CITY OF ALBUQUERQUE

November 21, 2022

**Re: 7441 Bartlett
7441 Bartlett St. NE
Traffic Circulation Layout
Architect's Stamp 10-31-22 (D17-D113)**

1 SITE PLAN
1" = 40'-0"
0' 10' 20' 40' 80'

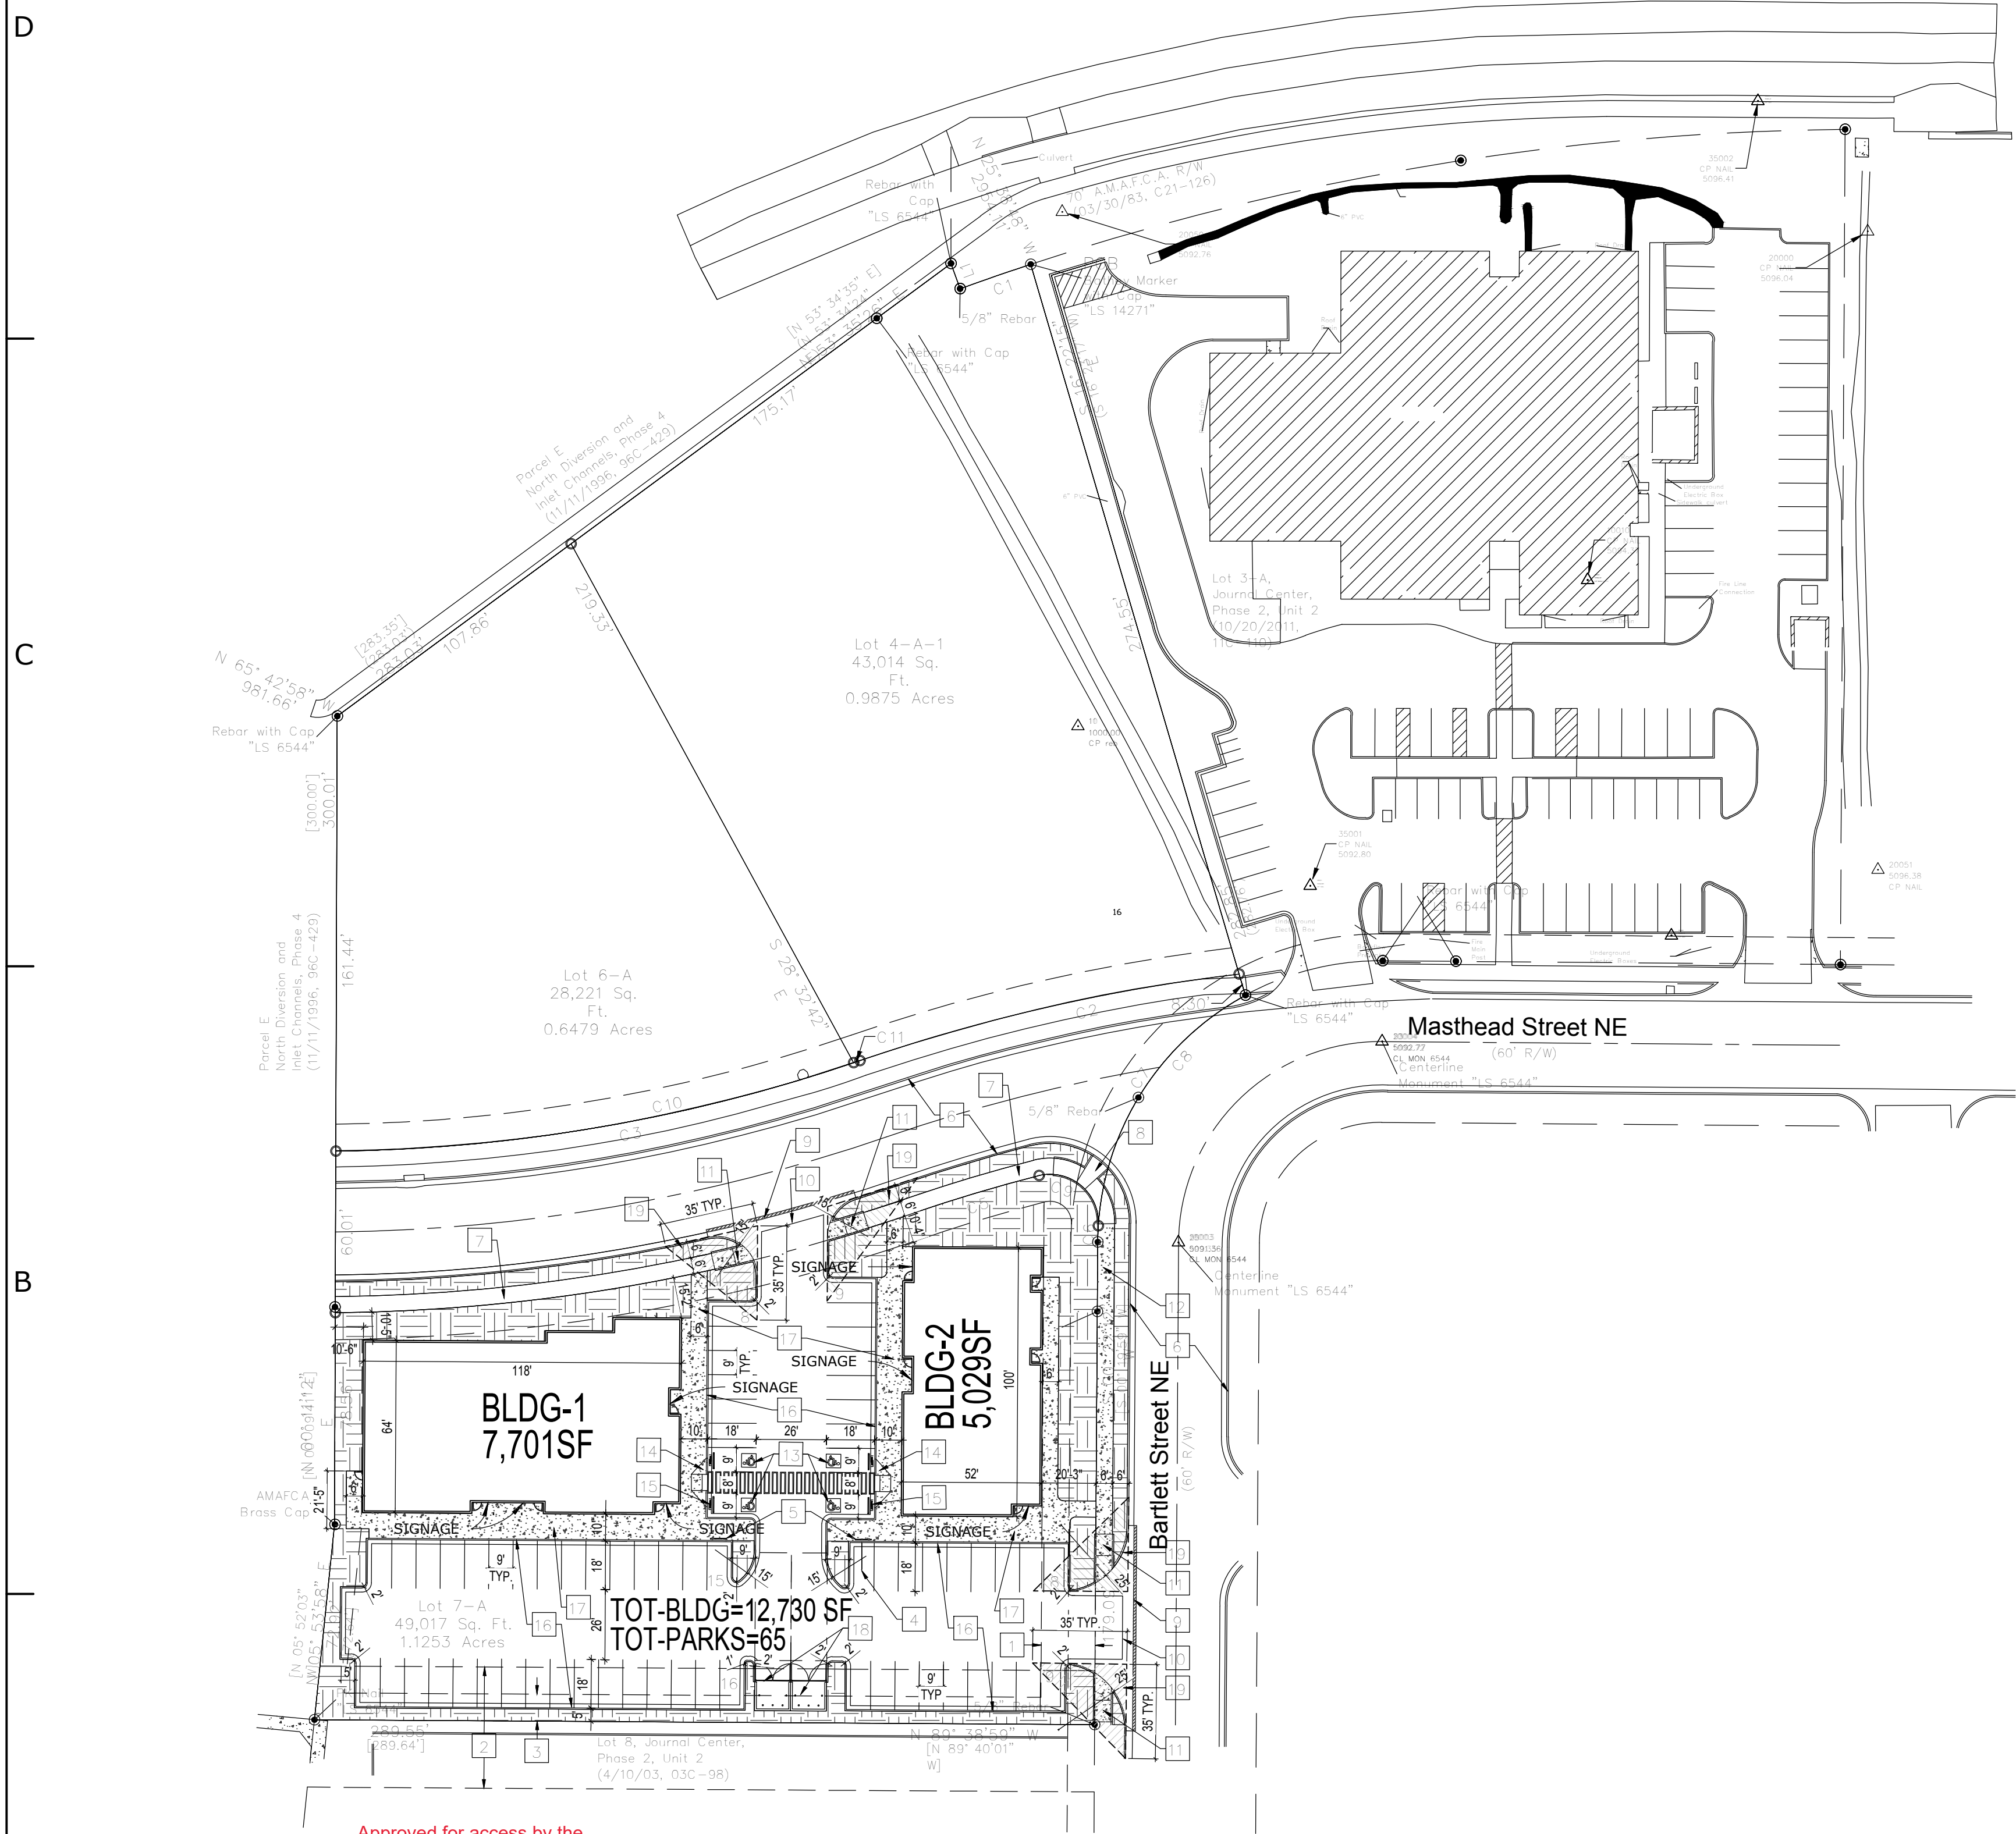
1. Identify all existing access easements and rights of way width dimensions.
2. Clarify existing property lines and proposed property lines.
3. Driveways accesses width need to be shown on the site plan.

4. The pavement marking "MC" should be shown in the opposite direction for Motorcycles entering the parking space.
5. Clear site triangle should be started at the back of the sidewalk. Please see the attachment.

6. Please provide a copy of Fire Marshal and Solid Waste approval.
7. It is not apparent what type of pavement surface is being proposed. A hard driving surface will be required as part of this proposed project for parking area and drive aisles.

8. Please remove all details that do not apply to this project (for example, the "DO NOT ENTER" sign).
9. Please specify the City Standard Drawing Number when applicable.

10. Work within the public right of way requires a work order with DRC approved plans.
11. Please add a note on the plan stating "All improvements located in the Right of Way must be included on the work order."

12. Add a note stating "All broken or cracked sidewalk must be replaced with sidewalk and curb & gutter." A build note must be provided referring to the appropriate City Standard drawing.
